From: Dan Grove <dan@grove.cx>
Sent: Friday, October 7, 2022 8:23 AM
To: Molly McGuire
Subject: An additional data point on 6950 Maker/File 2207-019

To further buttress the Existing Grade comments that I made about the 6950 project, I tried an experiment: I overlaid the 6950 house plans onto the site plans of 7145 SE 35th, the house immediately north of 6950 (and which we know was built on Existing Grade).

BUILDING ELEVATIONS

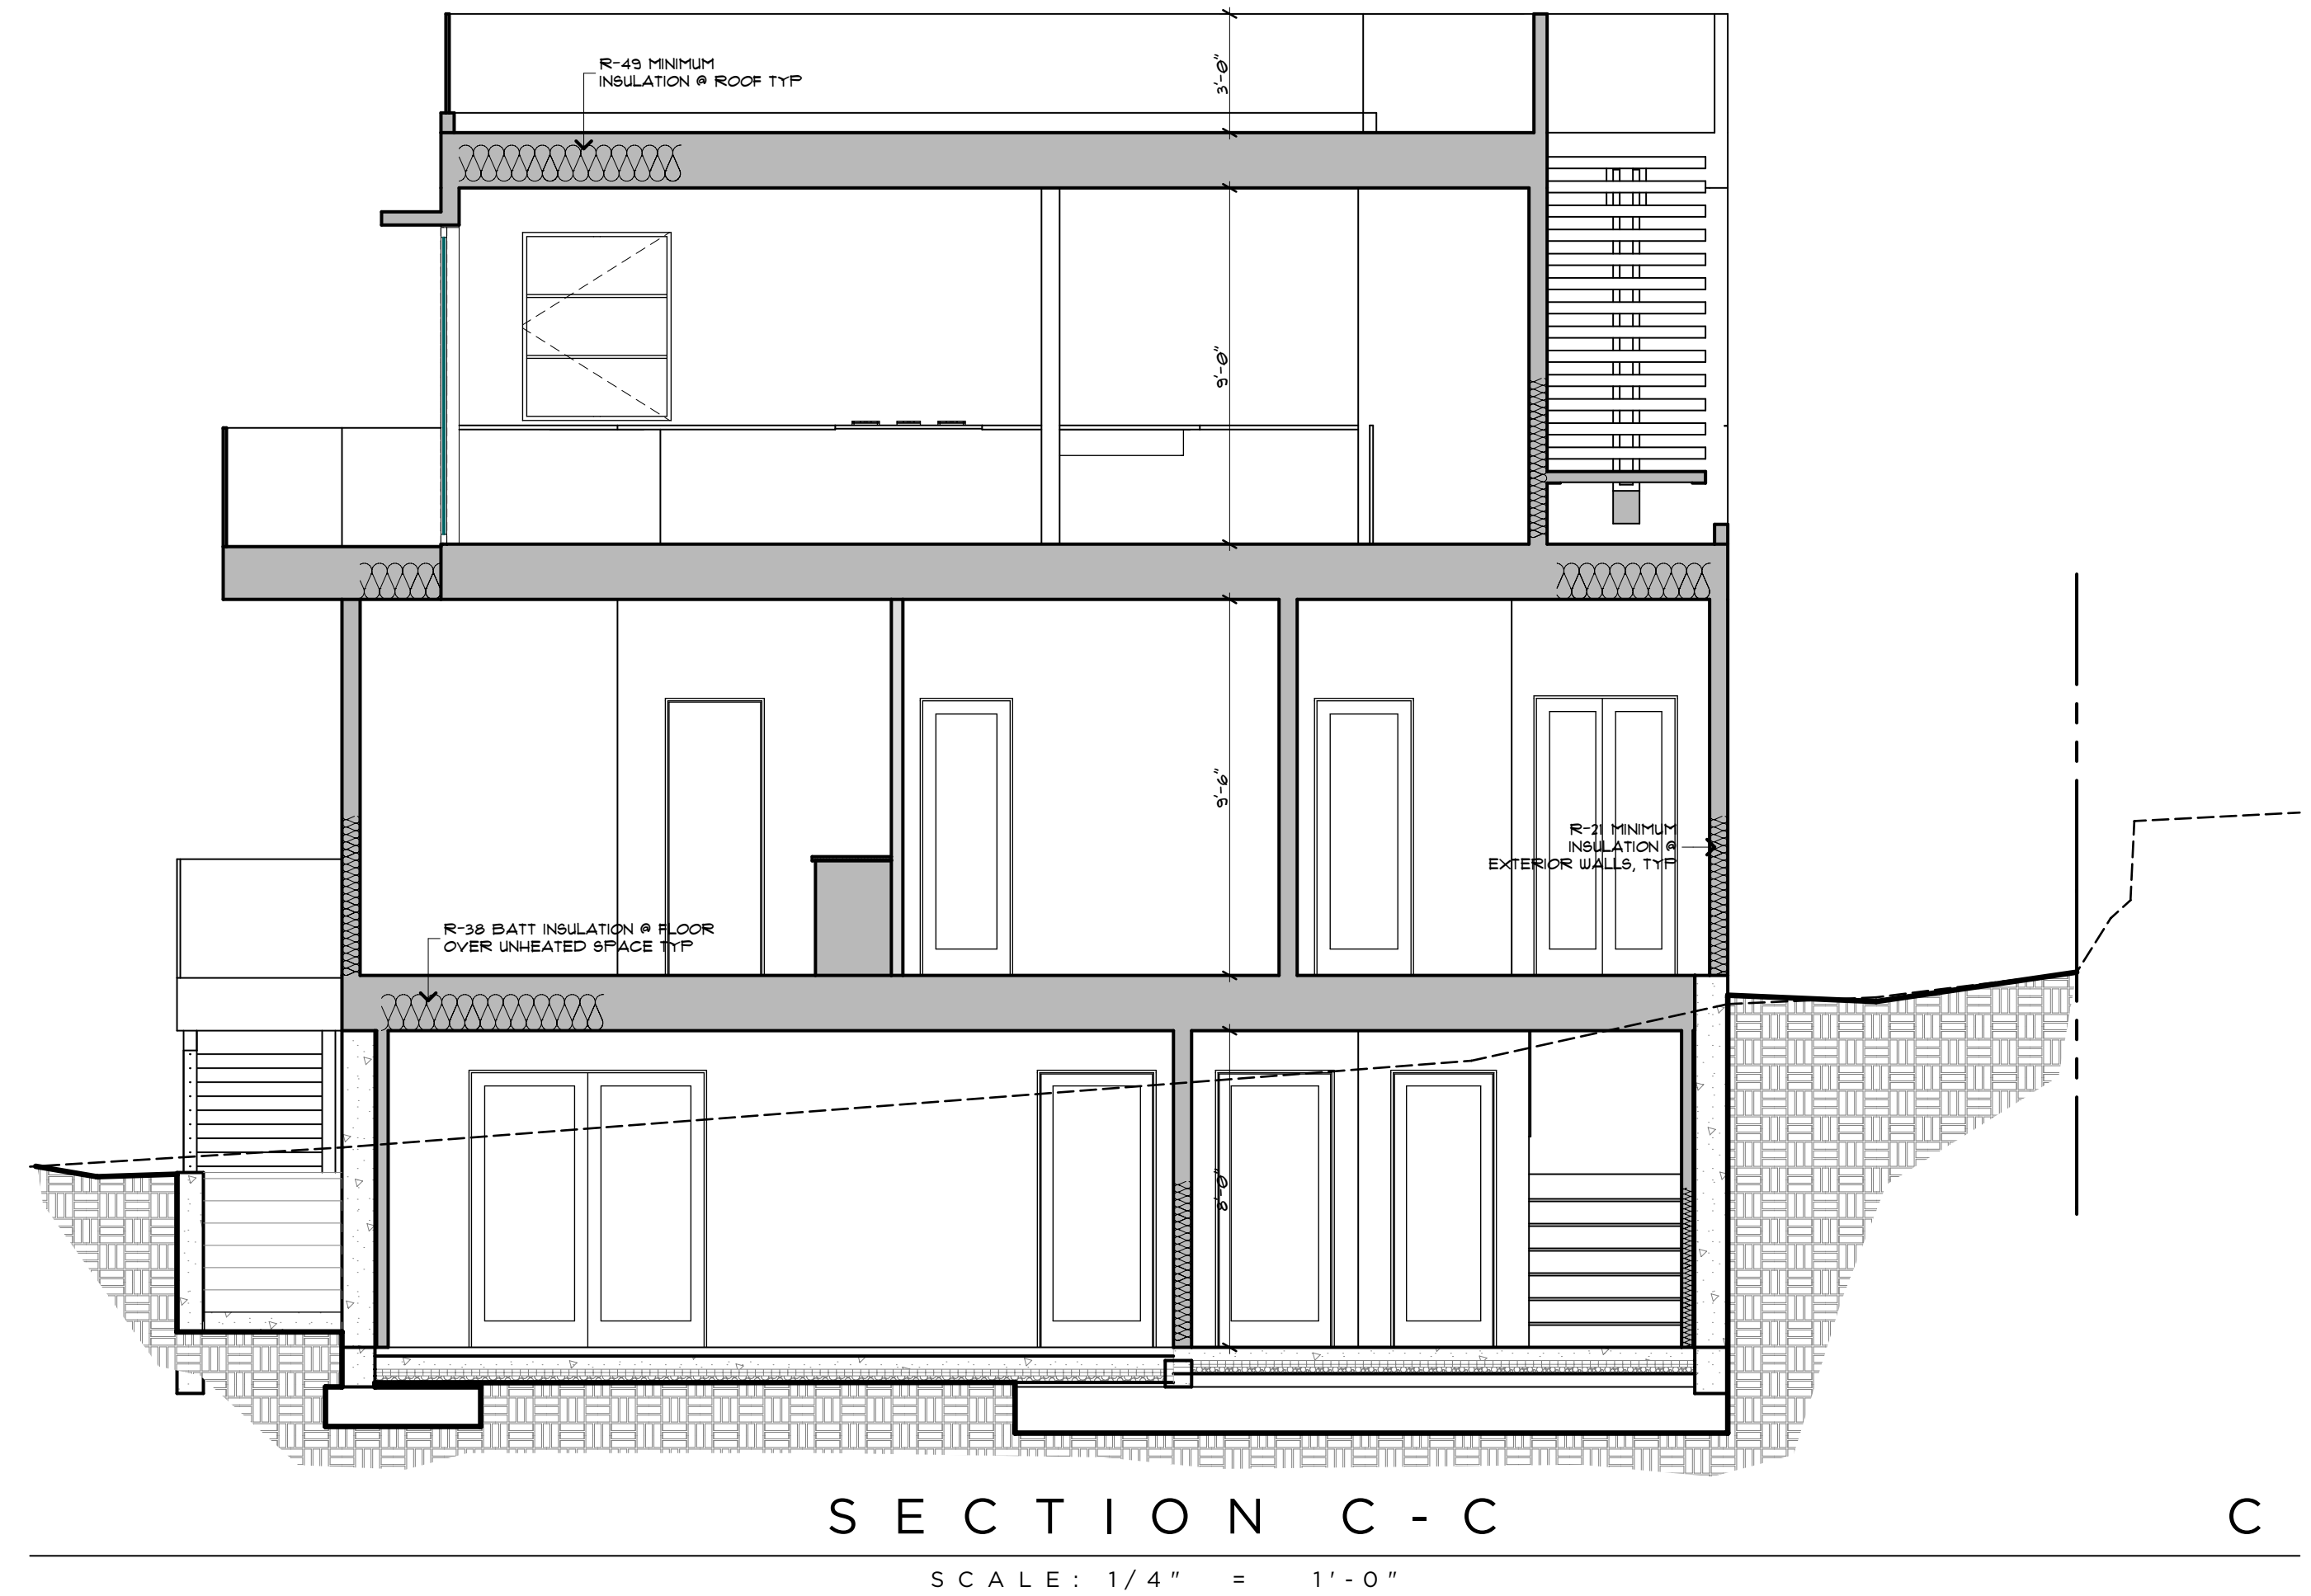
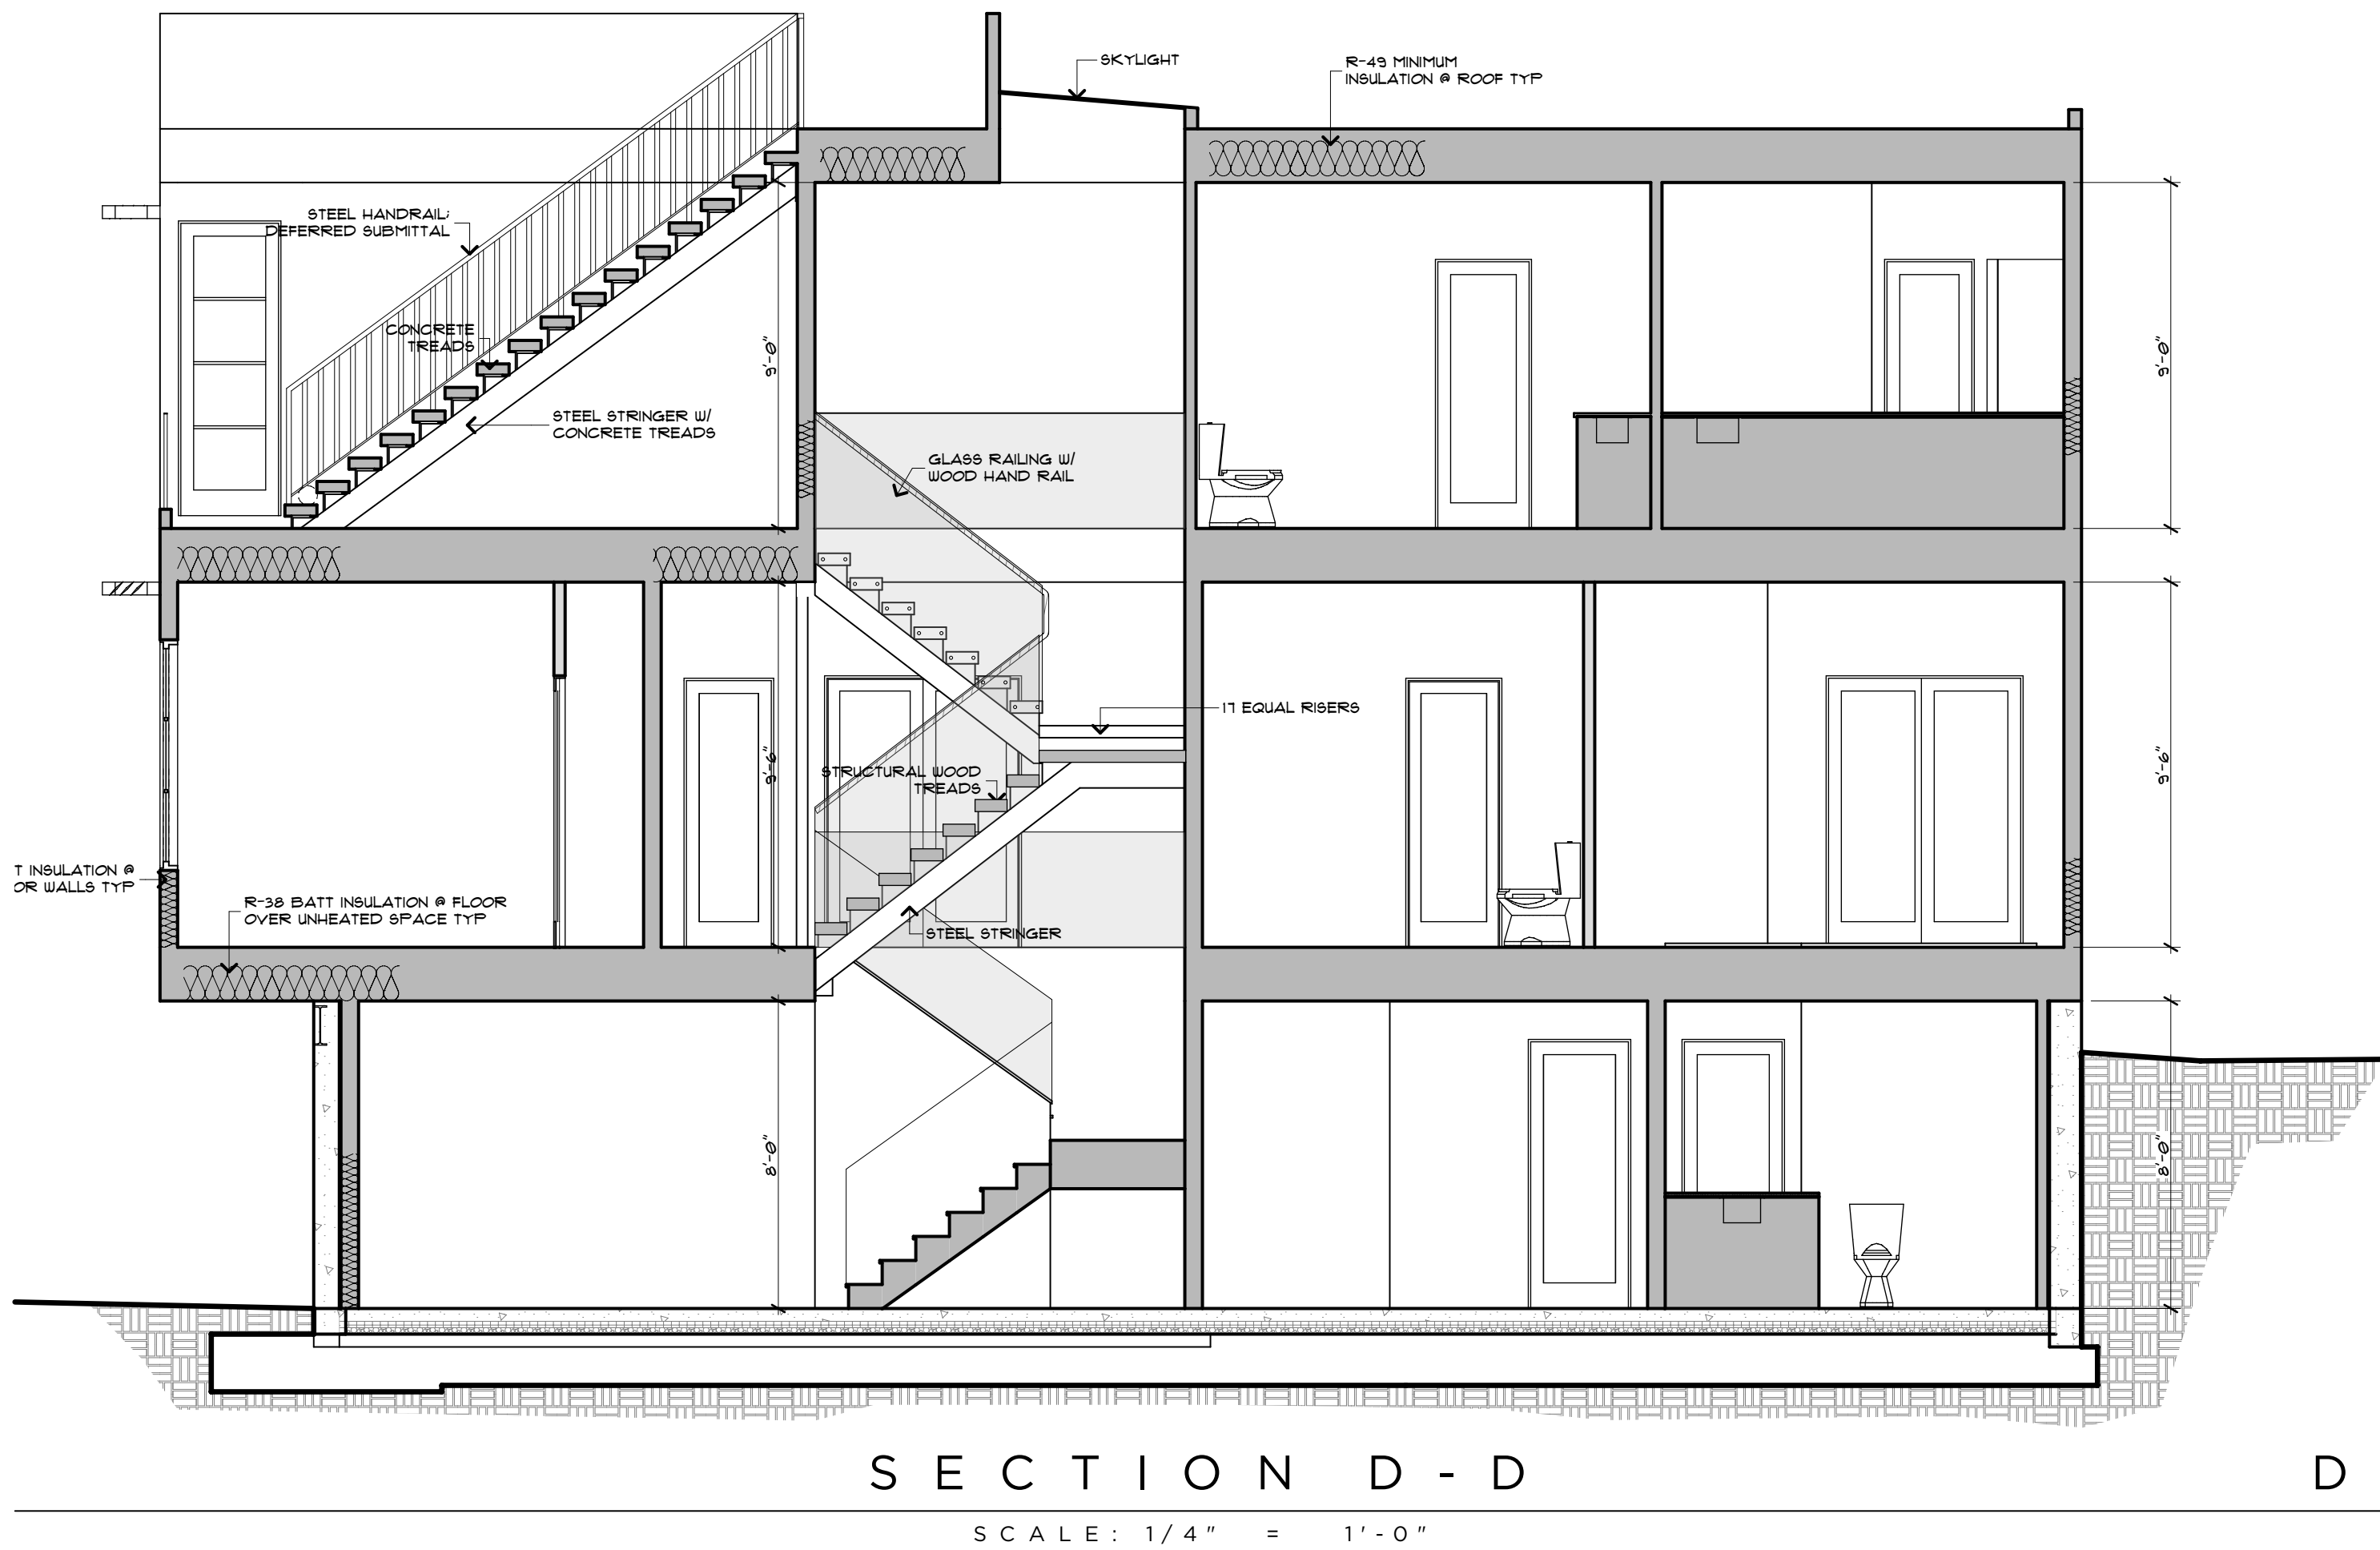
7145 is up the hill from 6950, but even on the 7145 lot, the 6950 project would have an ABE of ~229'. This is a good verification of the ABE that I presented in my formal comments.

You can see the outline of 6950 house (placed with the same borders N, S, E on the 7145 lot) in yellow, and the approximate ABE at the intersection of the red lines.
